CITY OF ALBUQUERQUE

December 30, 2020

Re: **The Strider**
109 Vassar Dr. SE
Traffic Circulation Layout
Architect's Stamp date *none* (K16D022A)

TCL

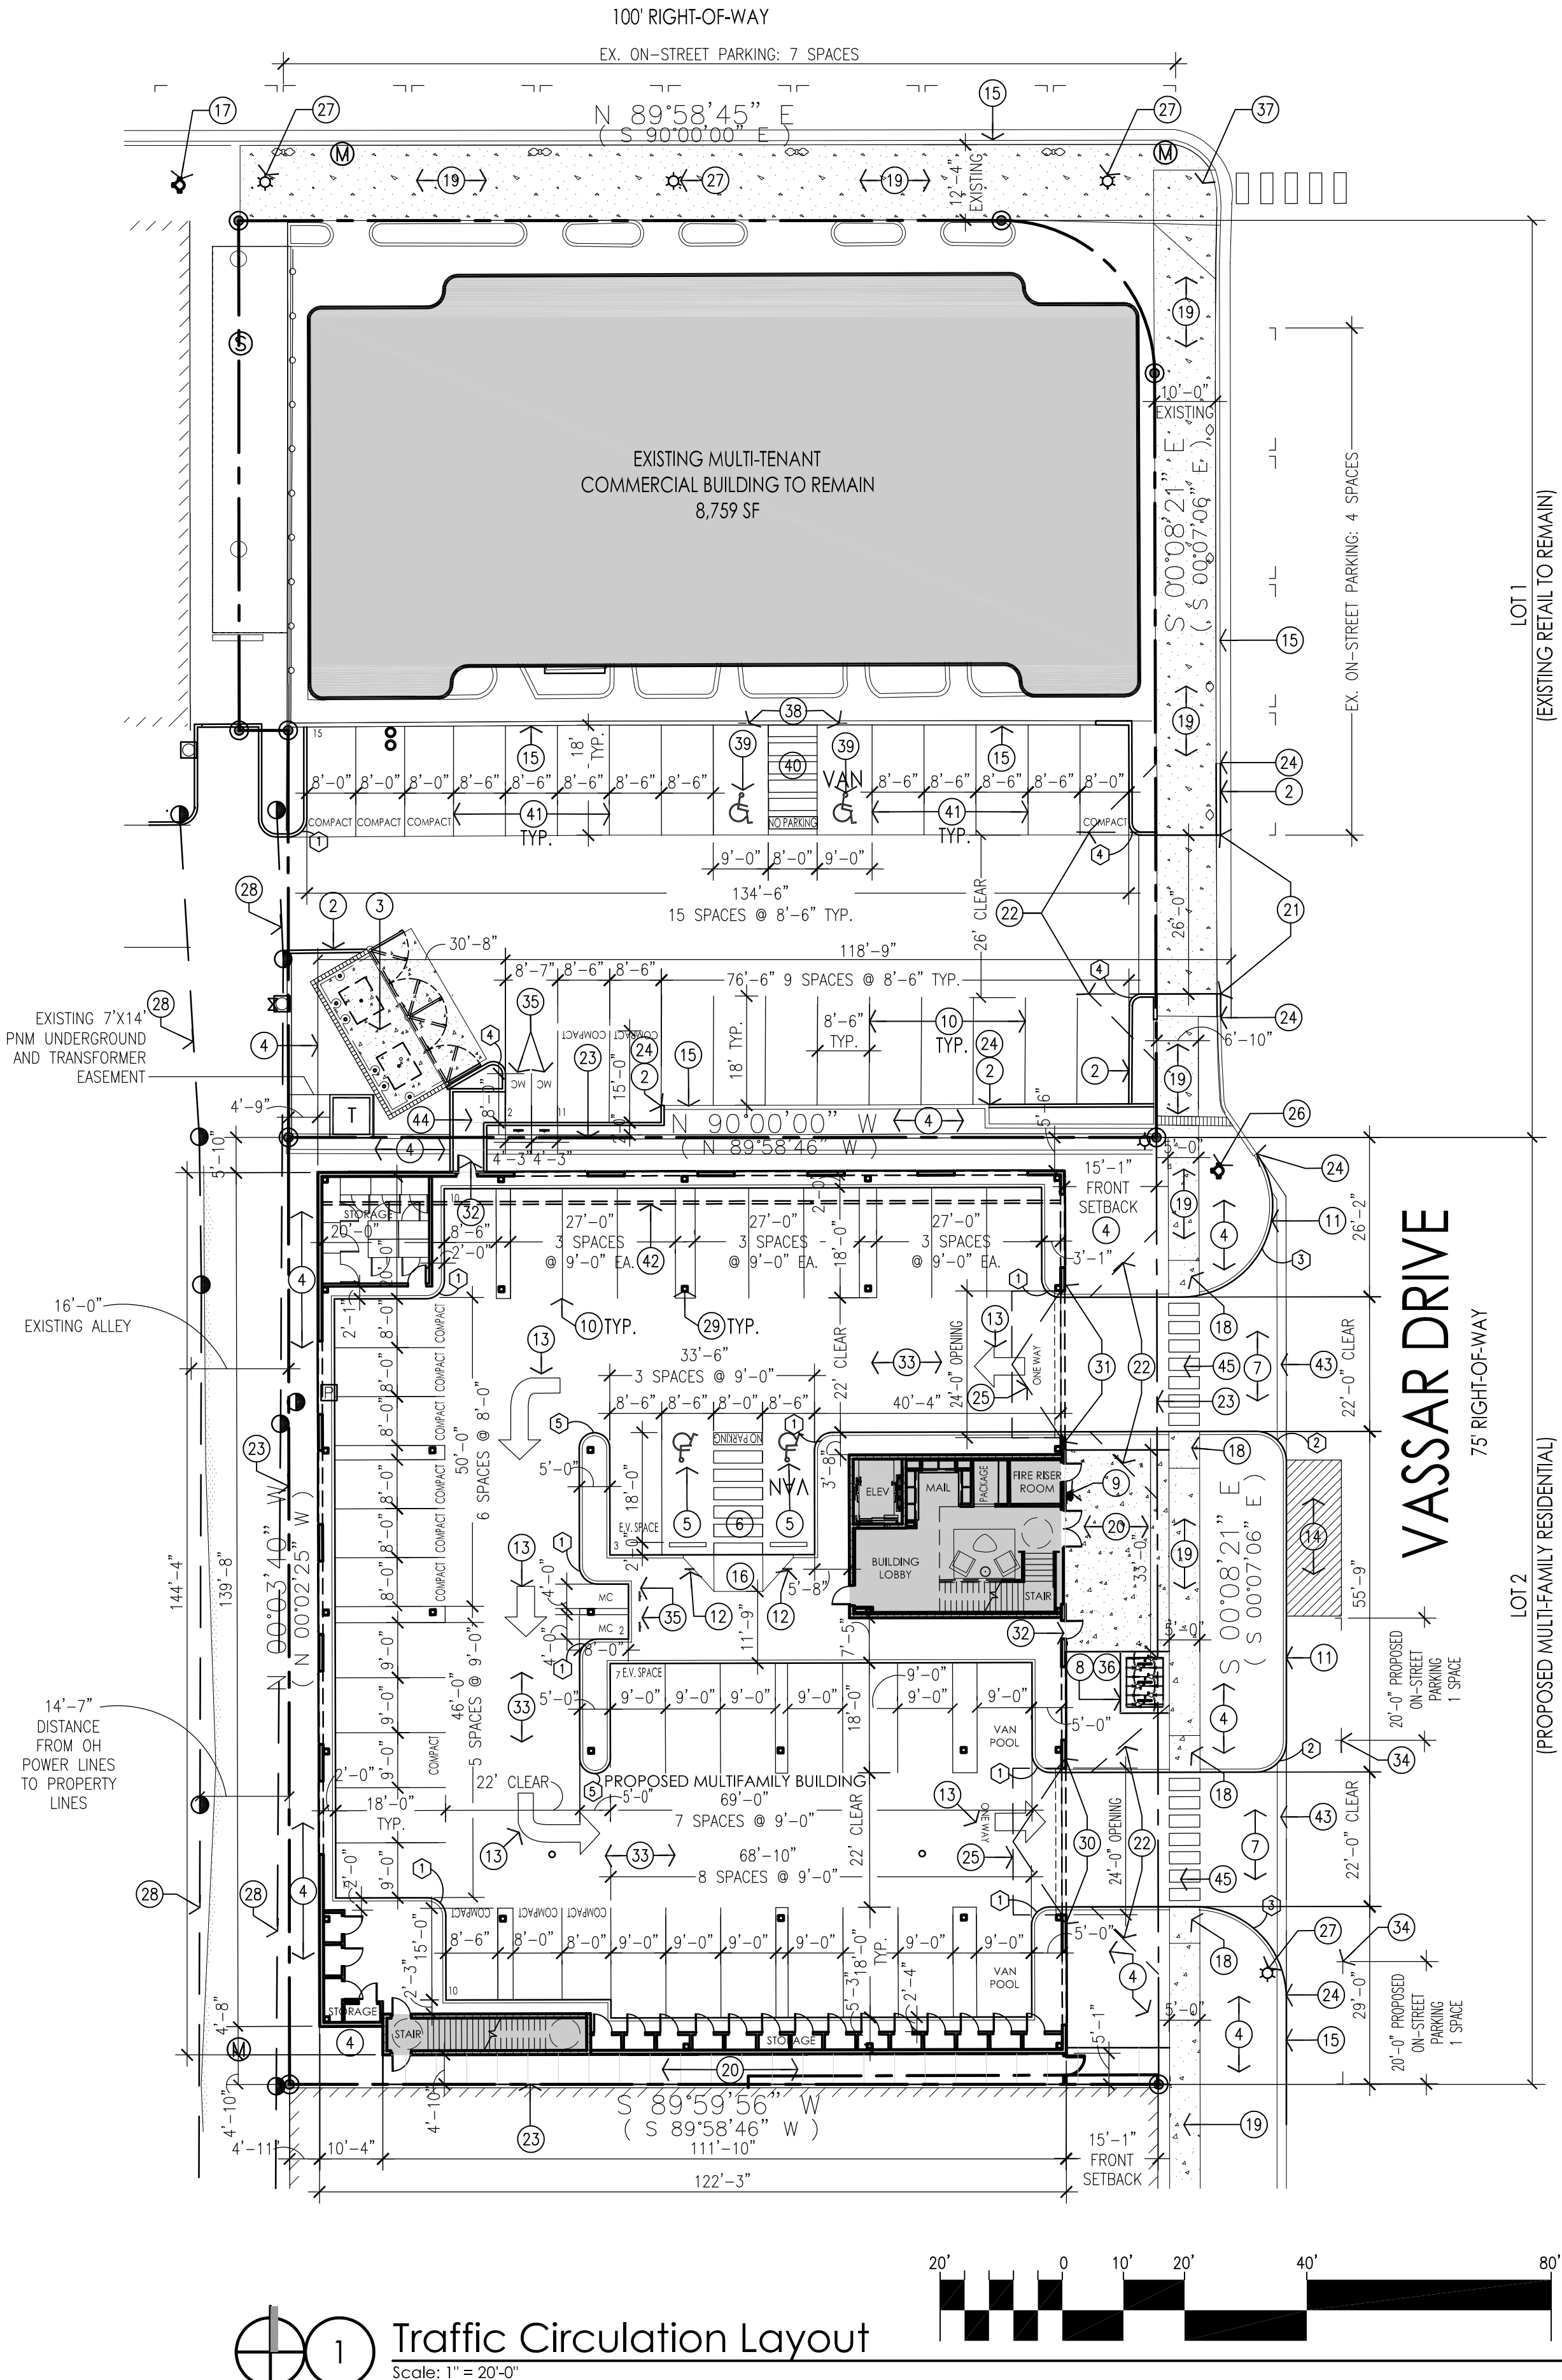
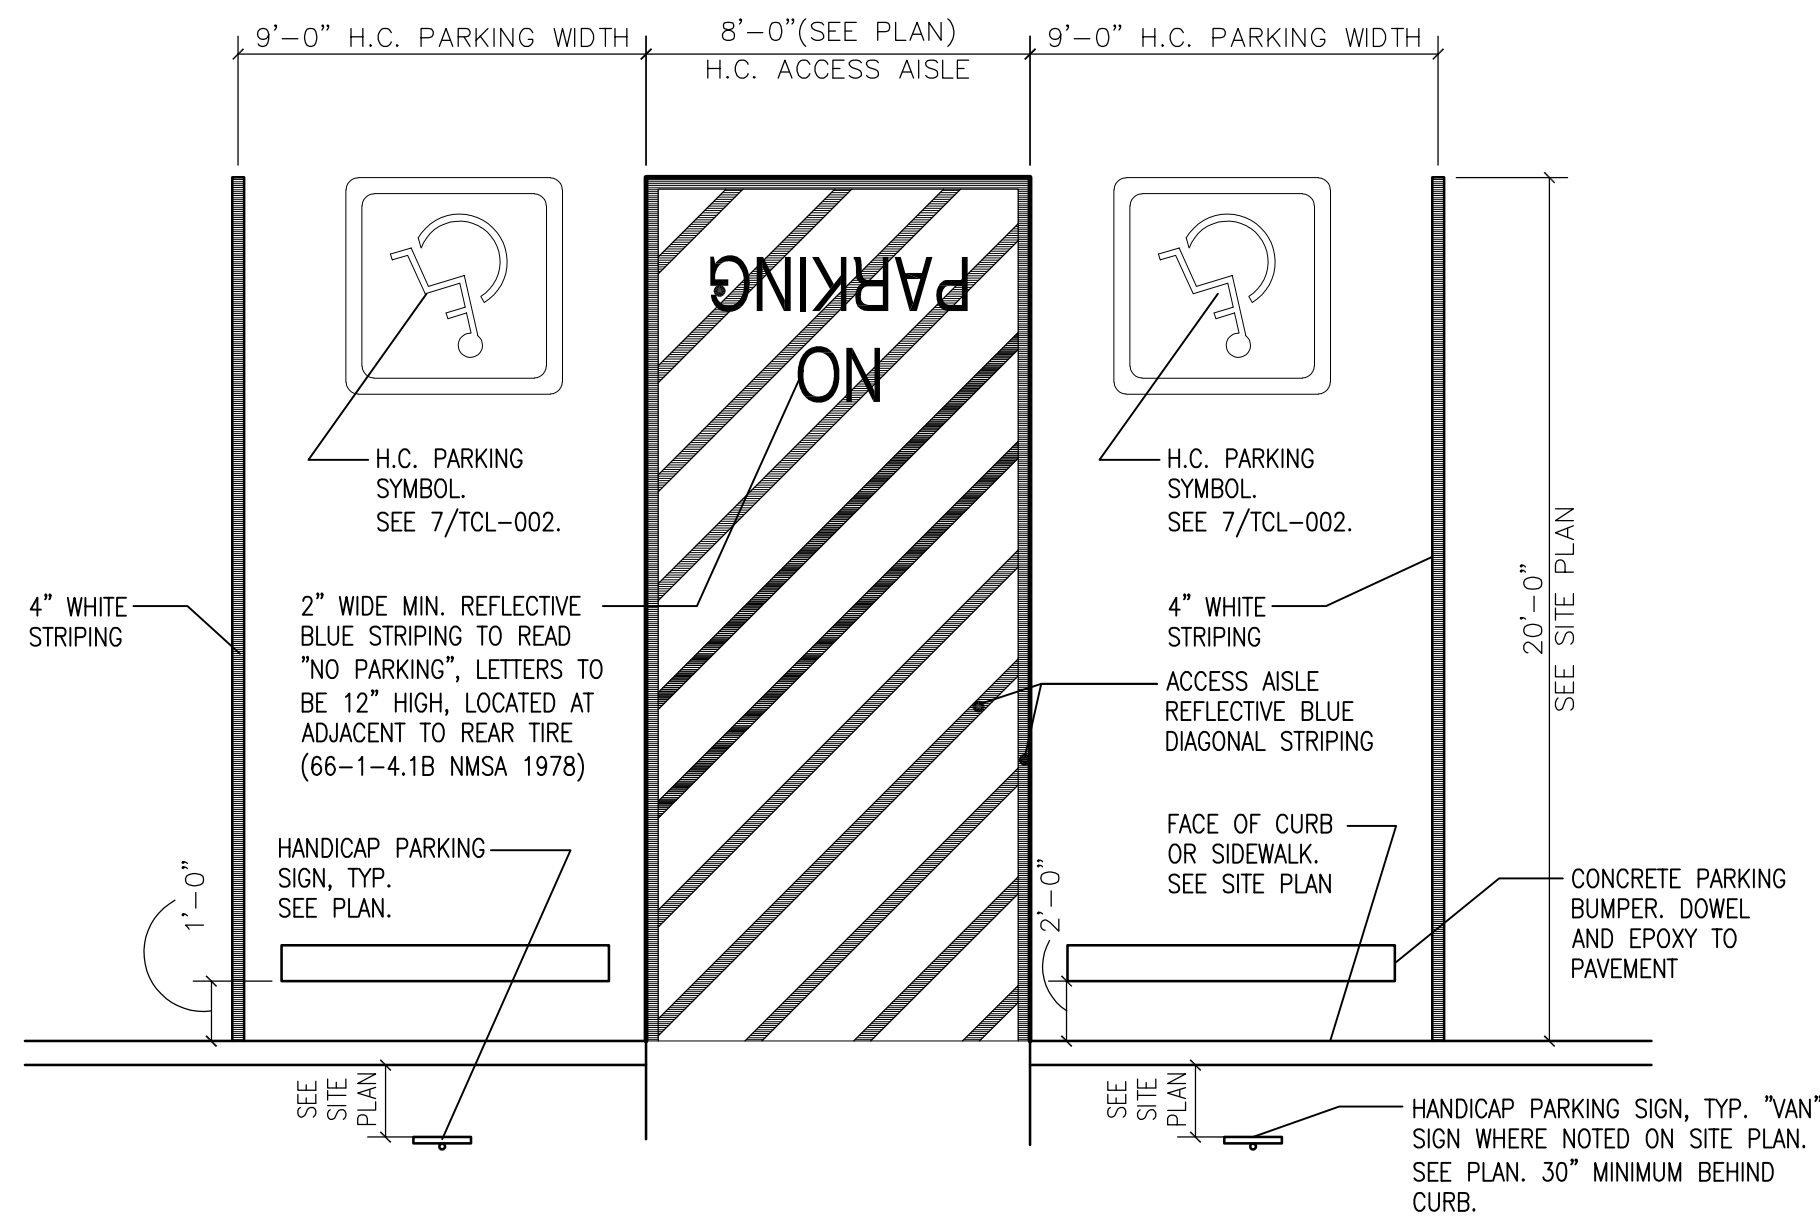
1. Provide the shared access agreement for the north parking lot shared with the Existing Multi-Tennent Commercial Building, 2720 Central Ave. SE.
2. Only plans that are sealed by a New Mexico licensed P.E or R.A. will be accepted for approval. Please seal all TCL submittal plans.
3. Show and describe all easements. If none please note on the plans.
4. On-street parking; provide approval from the City for use of the on-street parking.
5. Add construction detail for access driveways. Recommend using COA Std. Dwg. 2426 with concrete valley gutter. The flowline of the gutter needs to be continuous to properly convey stormwater.
6. Confirm the Fire Marshall's approval for fire and emergency access.
